MECKLENBURG COUNTY
Park and Recreation Department

MEMORANDUM

DATE: December 19, 2022

RE: Rezoning Petition #2022-126
PID# 05108127

AREA TO BE DEDICATED AND CONVEYED TO MECKLENBURG COUNTY FOR USE BY PARKS AND RECREATION. EXACT LIMITS TO BE DETERMINED DURING CONSTRUCTION DOCUMENT PERMITTING

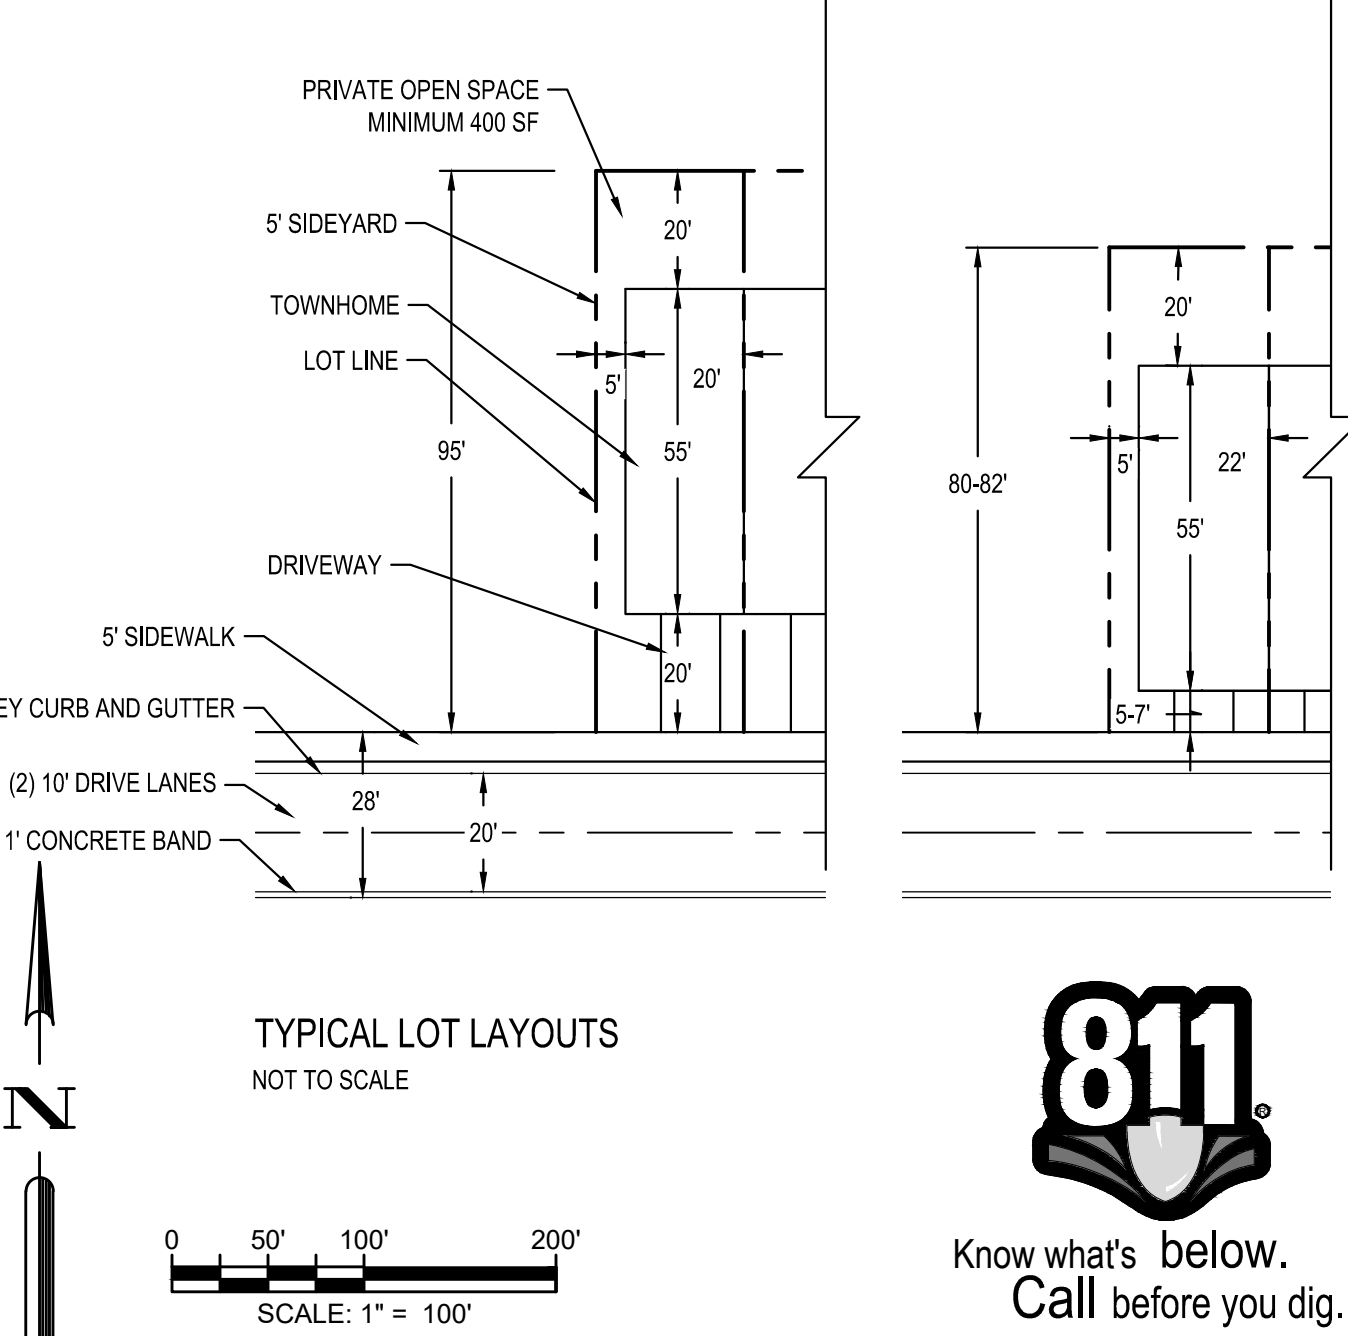
Change land dedication note to read: "Area to be dedicated and conveyed to Mecklenburg County for use by Park and Recreation".
